4th July 2019

Proposed part change of use (Class C3a) to form a single residential unit from two existing separate buildings. One building currently mixed use (part C3a & part A1) & the other residential (class C3a). Limited external works demolition boundary wall & external stairway - This application affects the character and appearance of Arundel Conservation Area
18A Tarrant Street Arundel

Thank you for your internet representation made on 3rd July 2019 which has been recorded as '**no objection**' with the comments as follows:

PROPOSED WEST ELEVATION FROM No. 20 TARRANT STREET 1:50

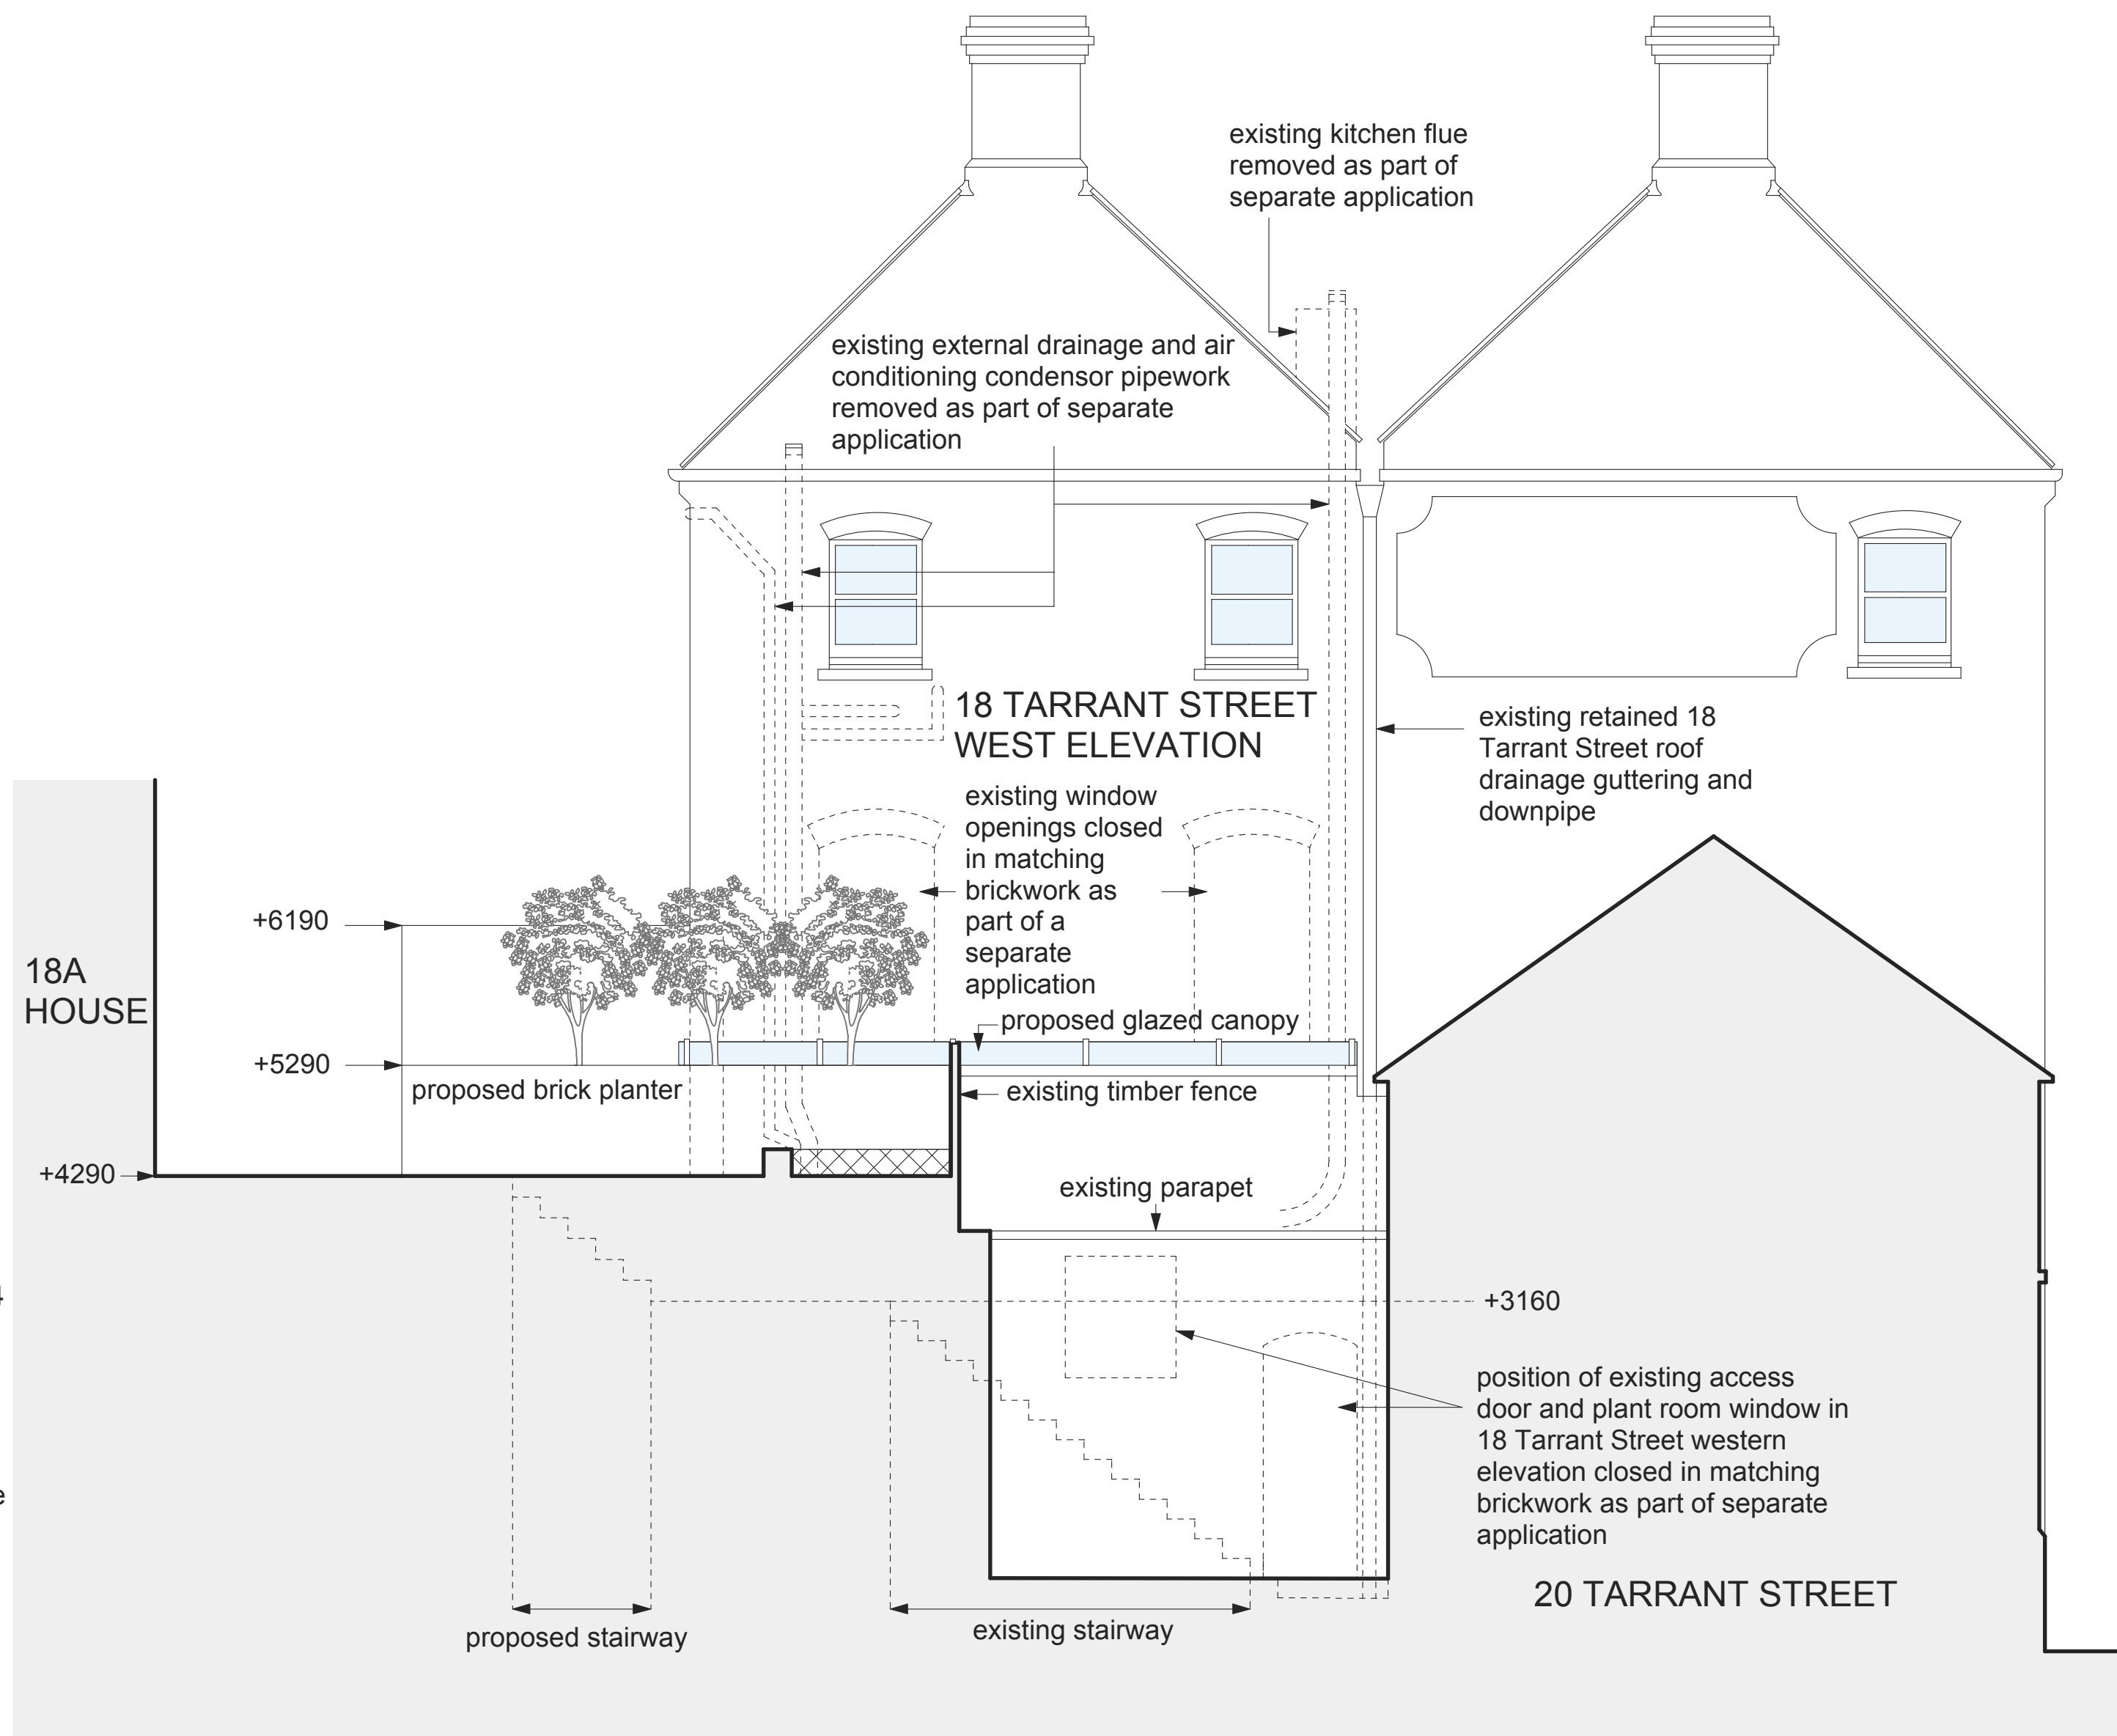
It is perhaps unfortunate that 3 windows and one doorway will need to be closed on the west elevation but these will not be seen from street level in Tarrant Street and unlikely to be immediately visible from other public areas. As such it is considered that the proposals will have no adverse impact on the character or appearance of the conservation area. The removal of the modern flues and air conditioning pipes on the west elevation is welcomed. If the Council is minded to grant planning permission then it is suggested that one of the attached conditions should ensure that precise details of the closing in of the windows and doors mentioned above should be submitted, together with a sample of the brick to be used. The Council may consider it important that, as historical record, the outlines of the existing openings are preserved by recessing the infilling brickwork.
